Ribble Valley Borough Council

## DELEGATED ITEM FILE REPORT - APPROVAL

Application No:	3/2014/0798/P
Development Proposed:	Single storey rear extension at The Bungalow, Clitheroe Road, Waddington, BB7 3HH.

SJ Biuletcki Limited Building Surveyors
Drawing no 7007 a
Scale 1:100 & 1:50
Proposed Single Storey Extension At The Bungalow Cliffhorne Road Waddington

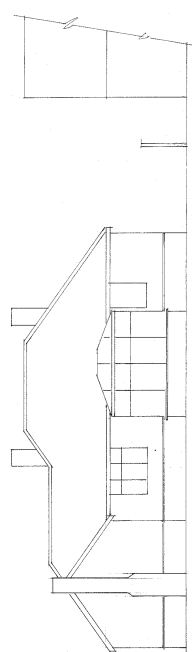
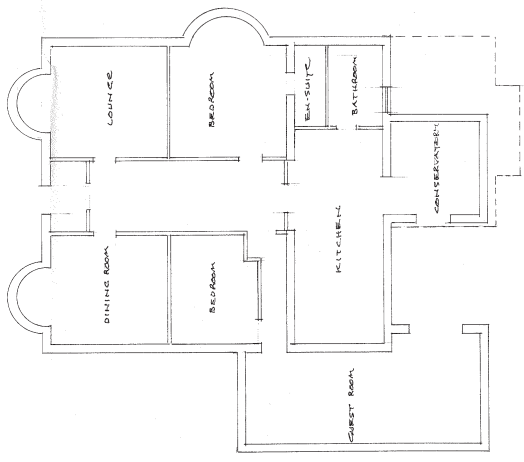
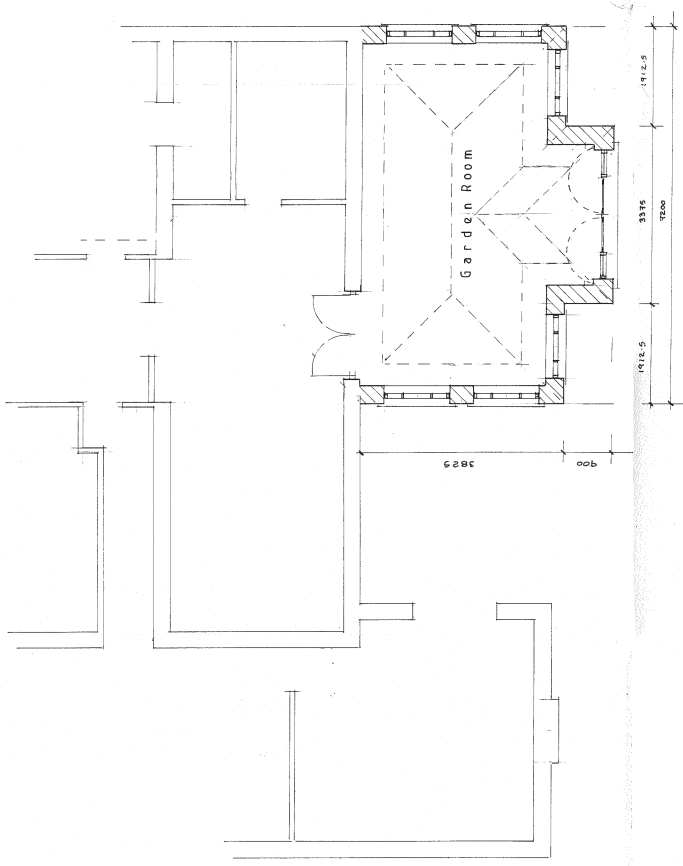
design matching the original house. Whilst the design itself was considered to be well thought out and would have looked visually attractive, concern was expressed about the overbearing impact the increased roof form, over and above the existing conservatory, would have on the neighbour of Hayday, particularly when using the rear garden area of the dwelling. There was also concern about the potential loss of sunlight to a bedroom window located close to the shared boundary. As a result of these concerns, the agent has re-designed the proposal by changing the roof of the extension to reflect a traditional orangery, as illustrated in the plans received on the 20<sup>th</sup> October 2014. The overall height of the roof has decreased by approximately 1.95m and the massing of the roofscape which caused neighbouring amenity concerns has significantly decreased. In addition, the boundary fencing and mature planting will protect any direct overlooking. I therefore consider the amended proposal to be acceptable in respect of the impact on residential amenity and in terms of its design.

S.J. Bialecki Limited Building Surveyors
Drawing no 7008
Scale 1:50
Proposed Single Storey Extension At The Bungalow Clitheroe Road Waddington

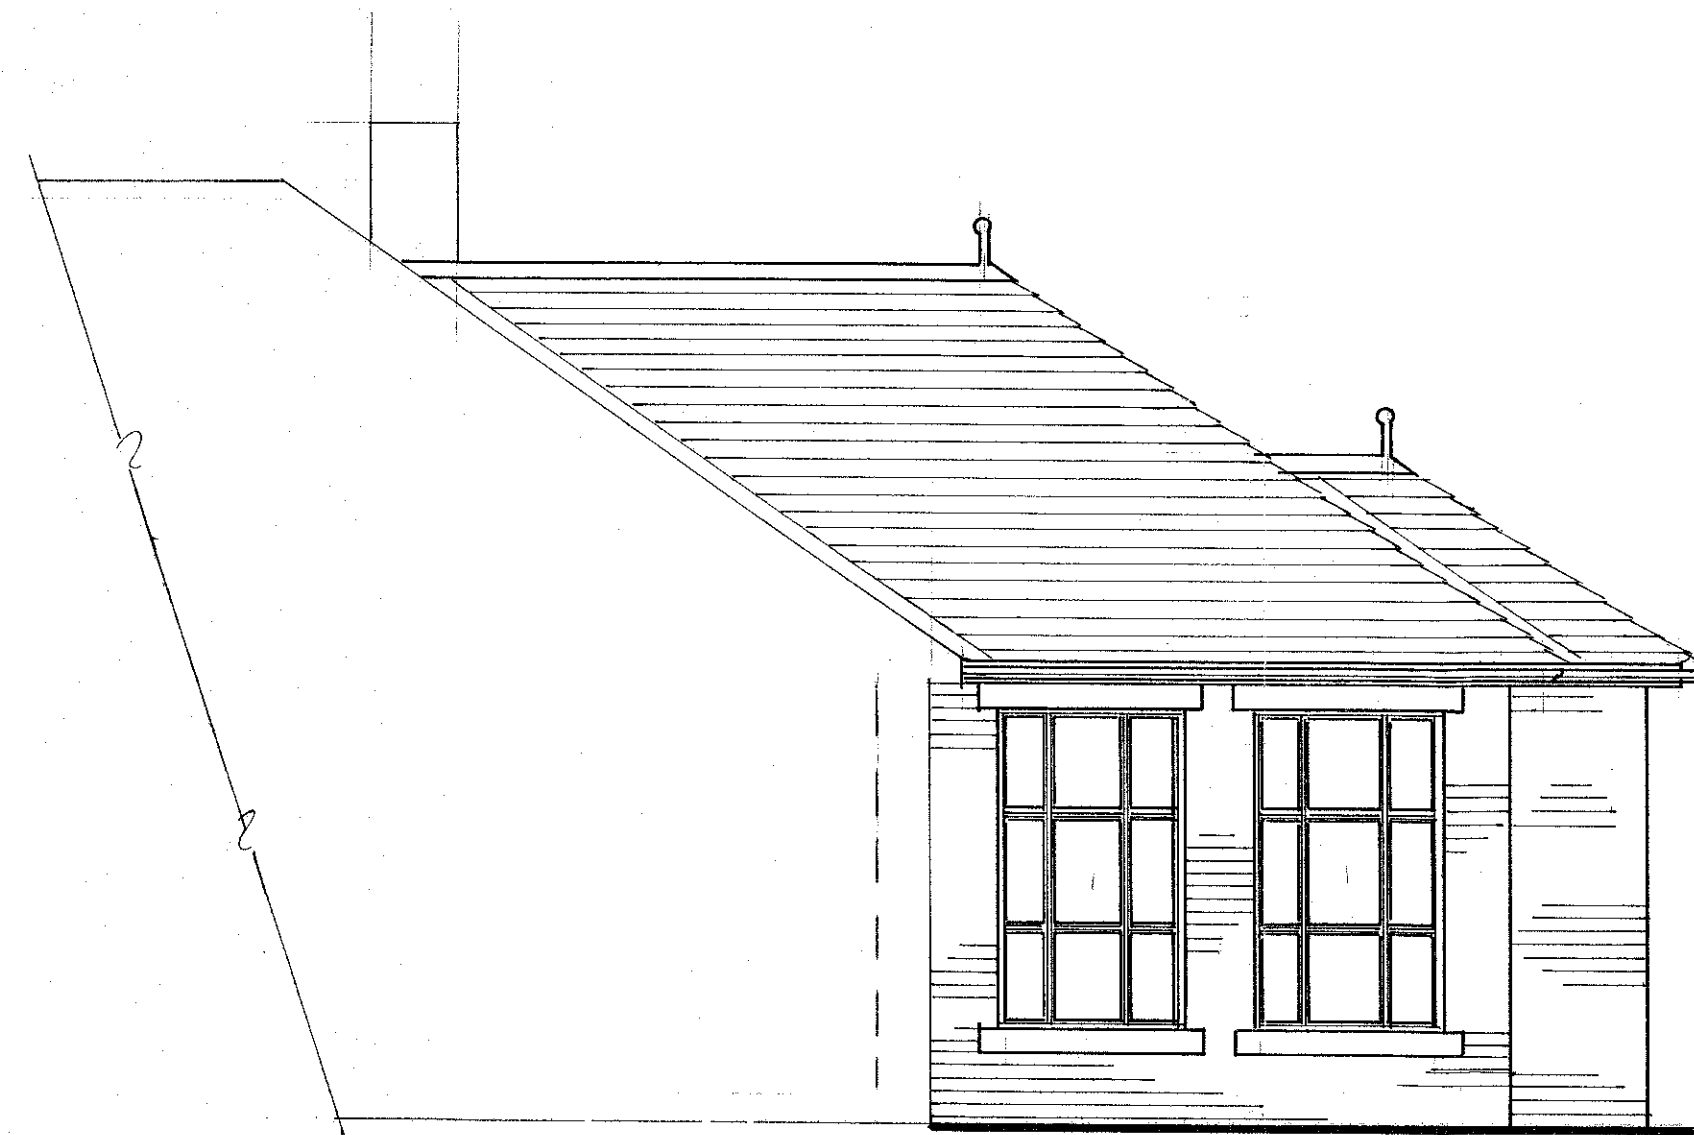
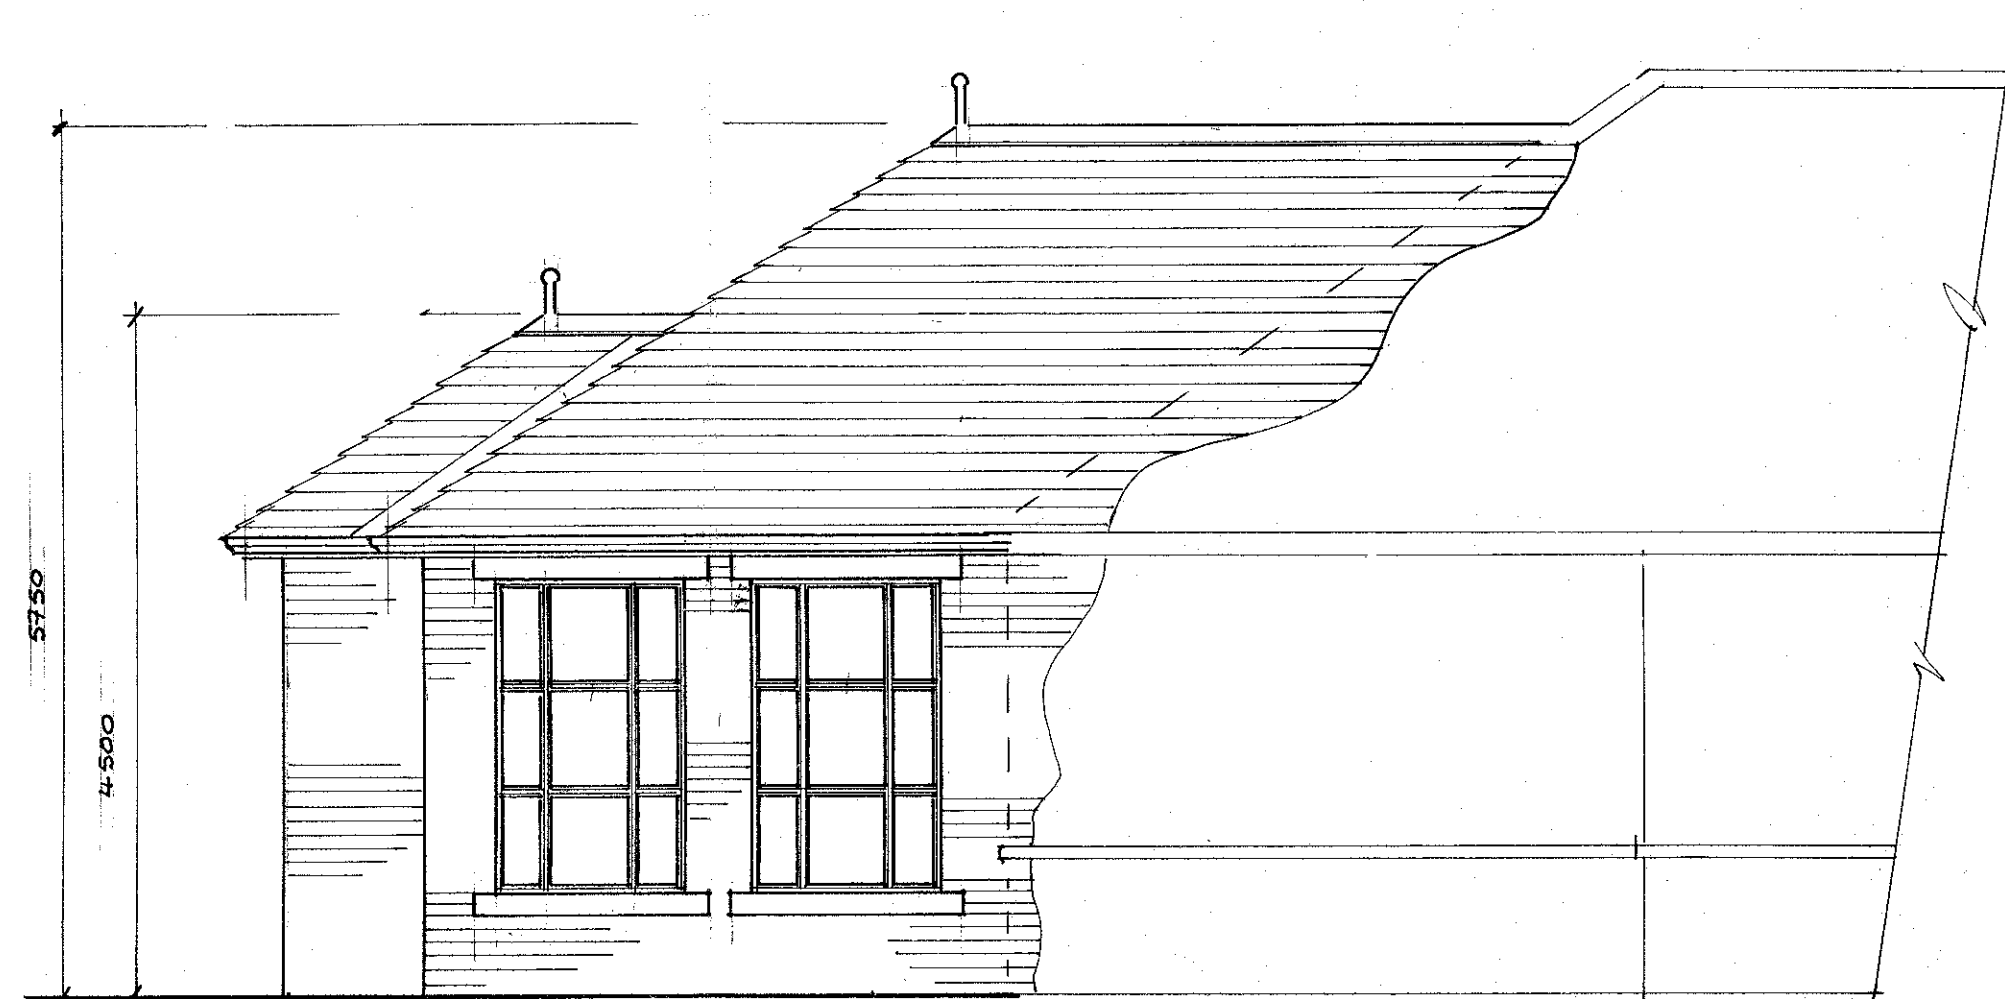
When the application was initially submitted, the proposals were for an extension with a rosemary tile roof that would extend off the west gable wall of the house with its scale and
